Initial Jury's Comments

Jury's Comments – 09/08/16

Painted steel palisade fence

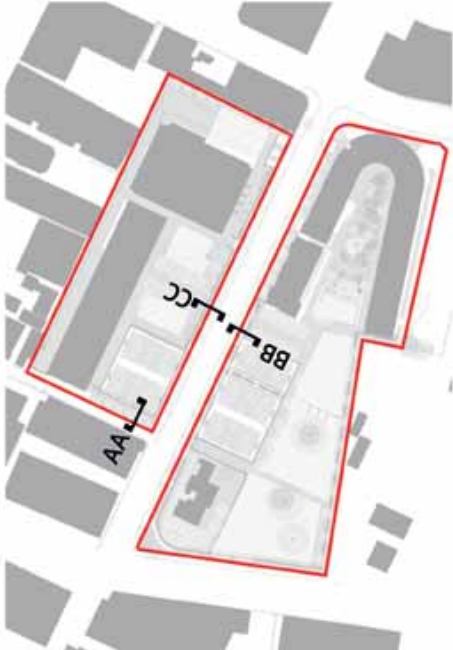
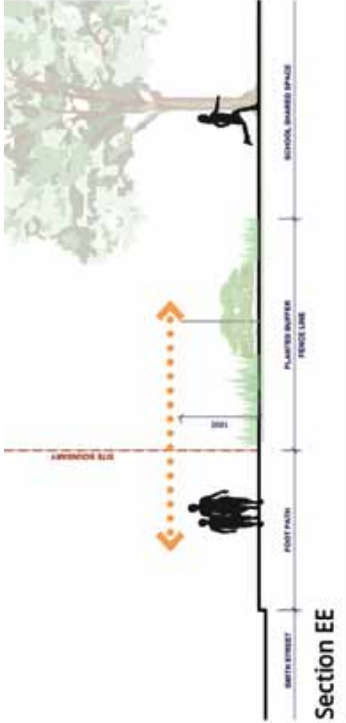
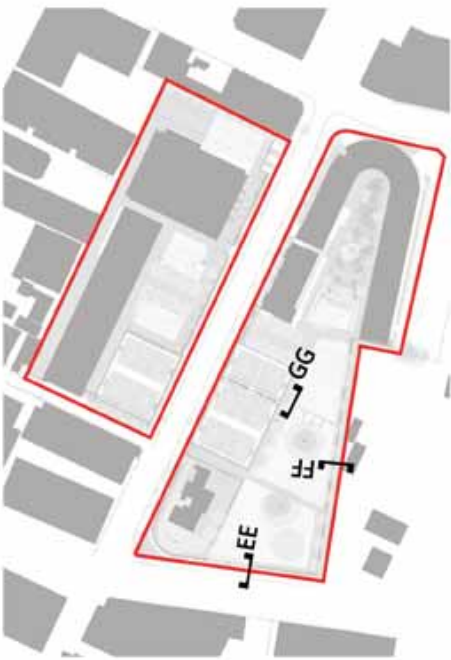
- Jury's comment:** Site fencing. The Jury does not support the perimeter fencing that has been introduced since the competition stage. While it is acknowledged that this has been introduced in response to security concerns, comparable public open space in Parramatta is not fenced and the Jury believes the approach here should be consistent with this and that security measures other than barriers be considered. In addition the fencing gives the impression of the school as a 'fortress' rather than community facility, and is seen to be inappropriate to this new "urban school" model, delivering yet again the suburban defensive model. There is a risk that the management of the school will result in the open space being unavailable to the community out of school hours. If there are limited locations where fencing may be appropriate (e.g. PPS courtyard) then it should be associated with hedge planting to reduce the visual impact.

Response: Security has been of upmost priority in the approach to the perimeter fence however the design of the fence and associated planted verge has been considered to ensure that the appearance is improved in the public realm. Multiple entrances have been provided around the perimeter of the school boundary to allow the site to be opened up and be as permeable as possible for community use and as the school may change in its approach in the future.
- Jury's comment: Access Paths.** The Jury is concerned that a public access path to Parramatta Square has been deleted and does not support this proposal. Such pathways are common in urban centres and there are many examples in the City of Sydney. An overreaction to potential security
